**KIRKLEES COUNCIL
TOWN AND COUNTRY PLANNING ACT 1990
HIGHWAYS DEVELOPMENT MANAGEMENT**

PLANNING REF 2018/60/92832/E0/ET
CATEGORY Minor

PROPOSAL OUTLINE APPLICATION FOR
ERECTION OF DETACHED
DWELLING

LOCATION WOODLEY
10 BUSKER LANE
SKELMANTHORPE
HUDDERSFIELD
HD8 9EP

Proposed Block Plan
1:500

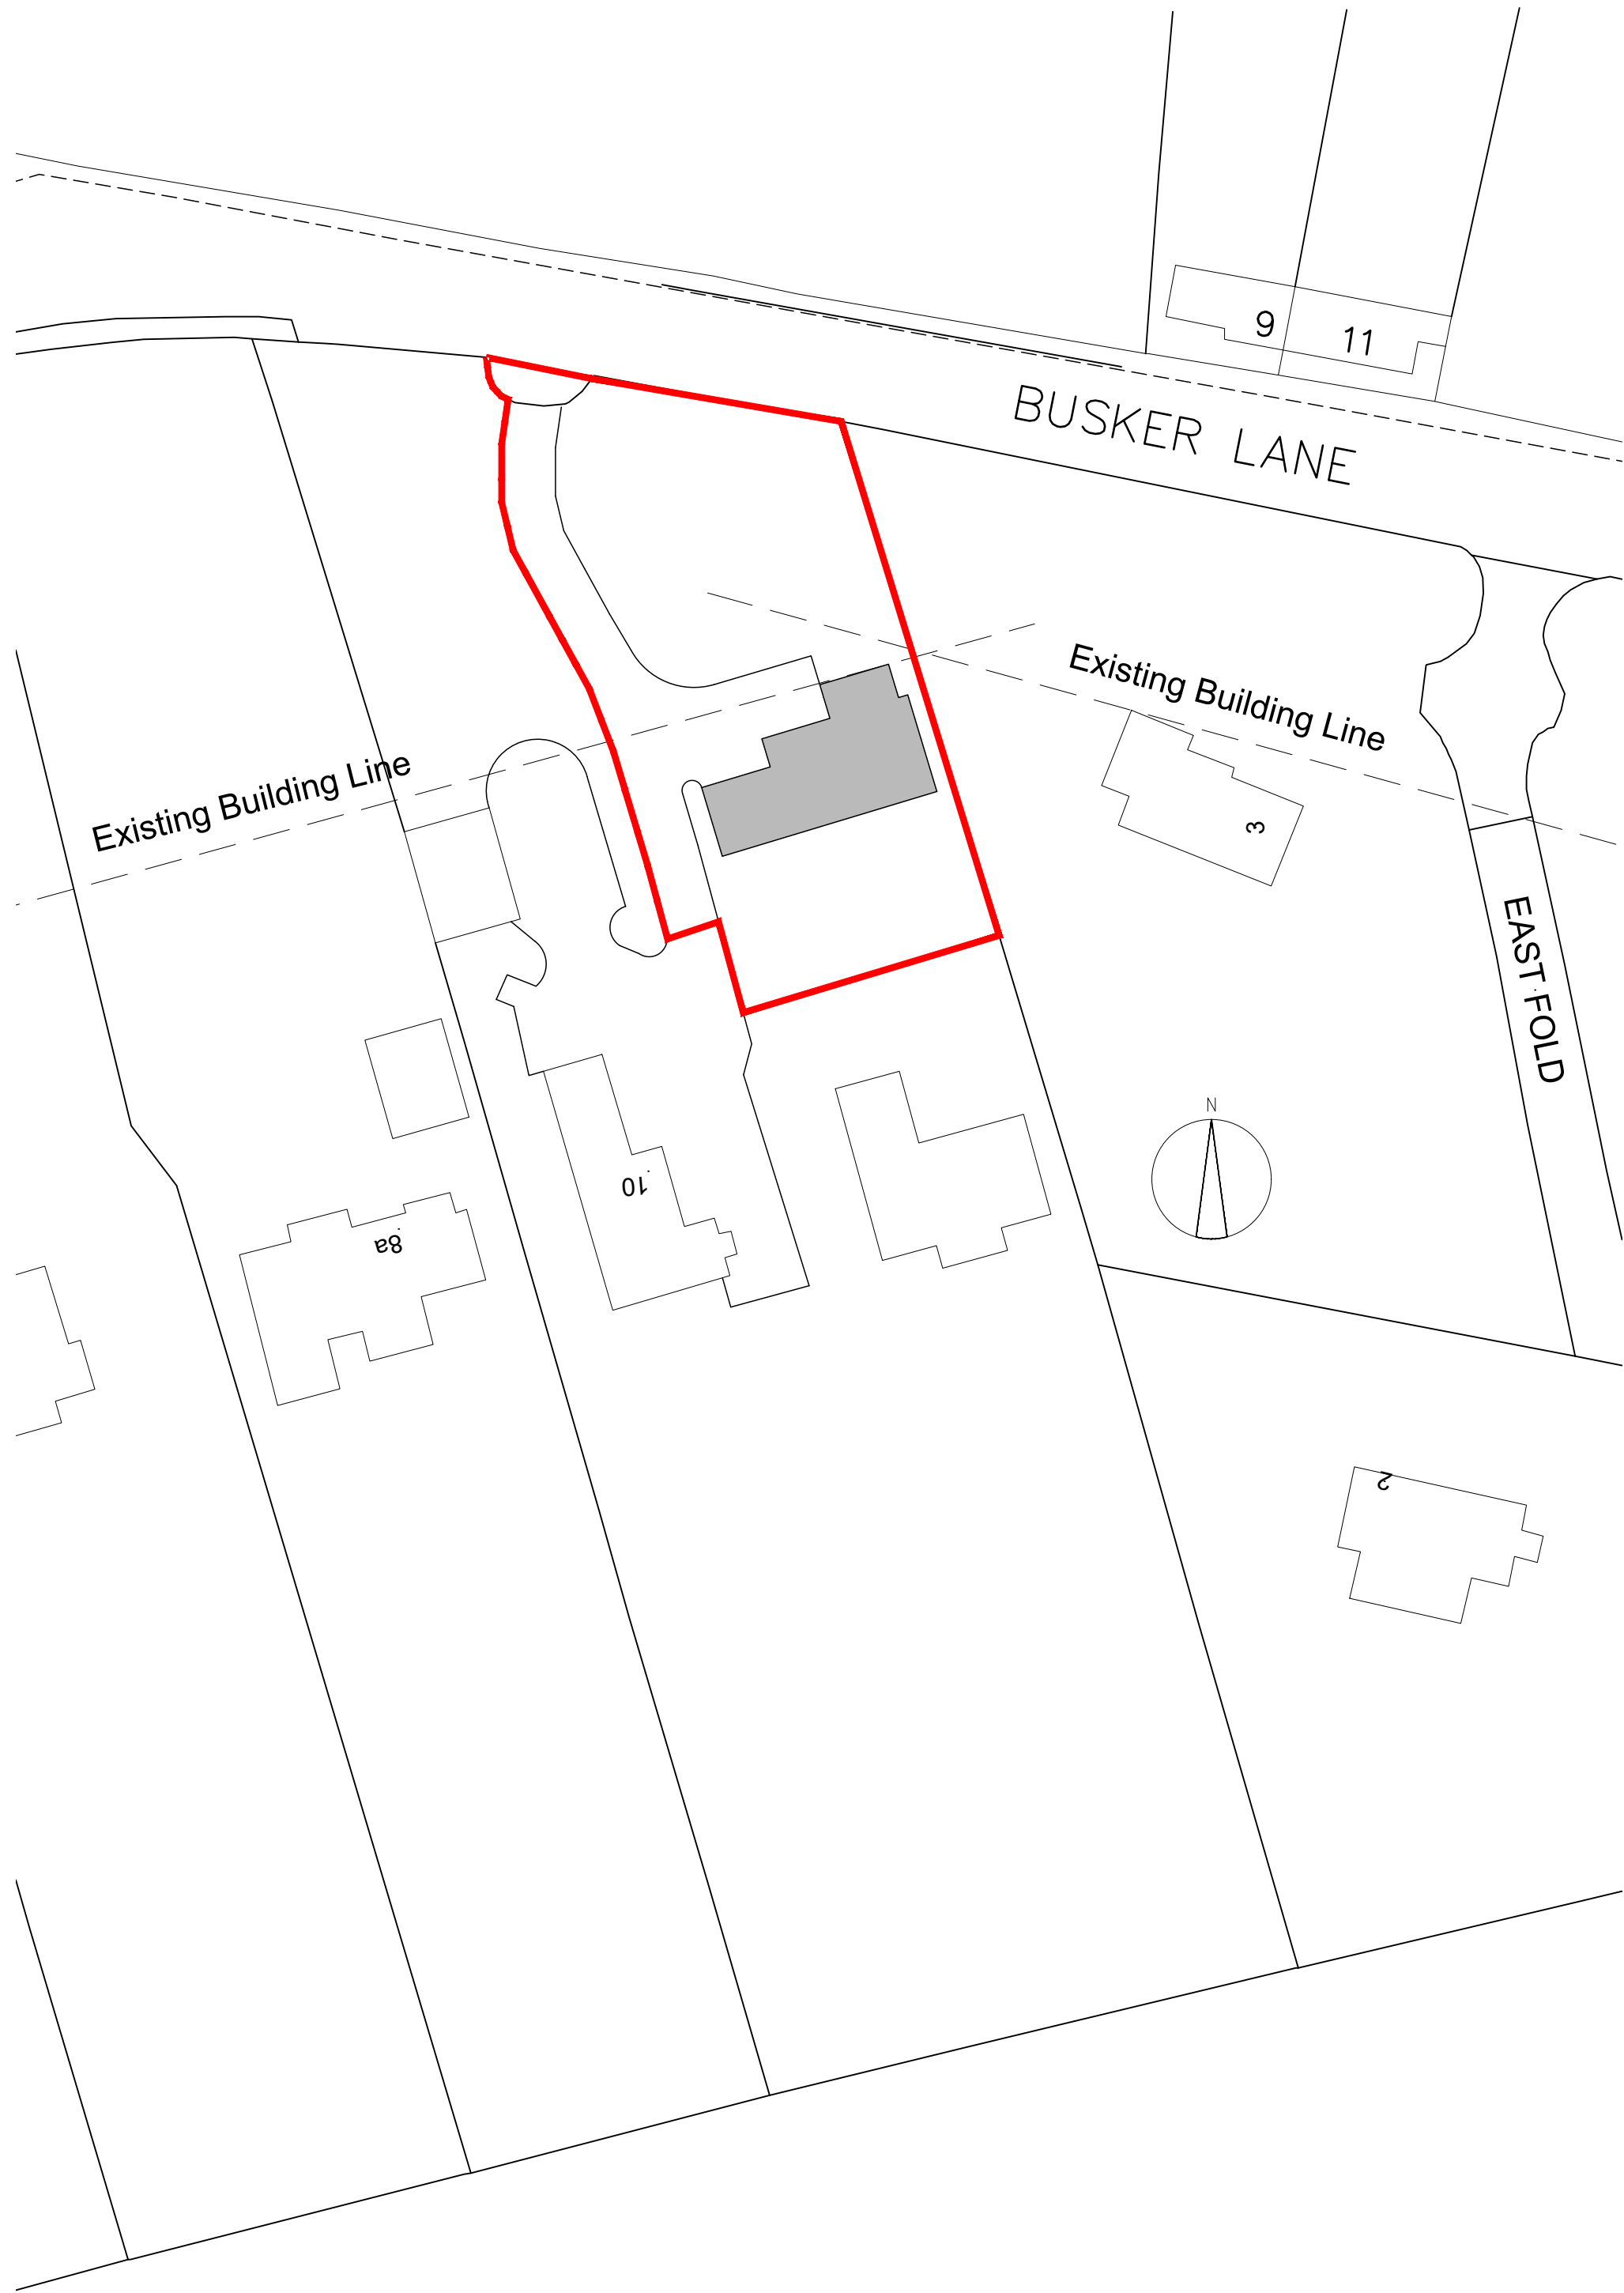
At this outline stage, Highways DM would wish to see improvements to the access to allow vehicles to pass each other where it serves more than one dwelling; a minimum width of 4.5m would be required.

Currently, the sight-lines from the access are substandard, and, given the proposed intensification of use of this site, Highways DM would wish for these to be improved to the guideline splays set out in Manual for Streets, namely 2.4m x 43m. It is likely this could be achieved by lowering the existing walls and planting nothing taller than 1.0m within 2m of the carriageway edge, then being retained in perpetuity by condition.

It is apparent that there is ample opportunity for adequate off-street parking to be created, but any full application should include parking and turning provision in line with Kirklees standards set out in Appendix 2 of the UDP.

- Access improvements showing visibility and widening as per the above recommendation.
-
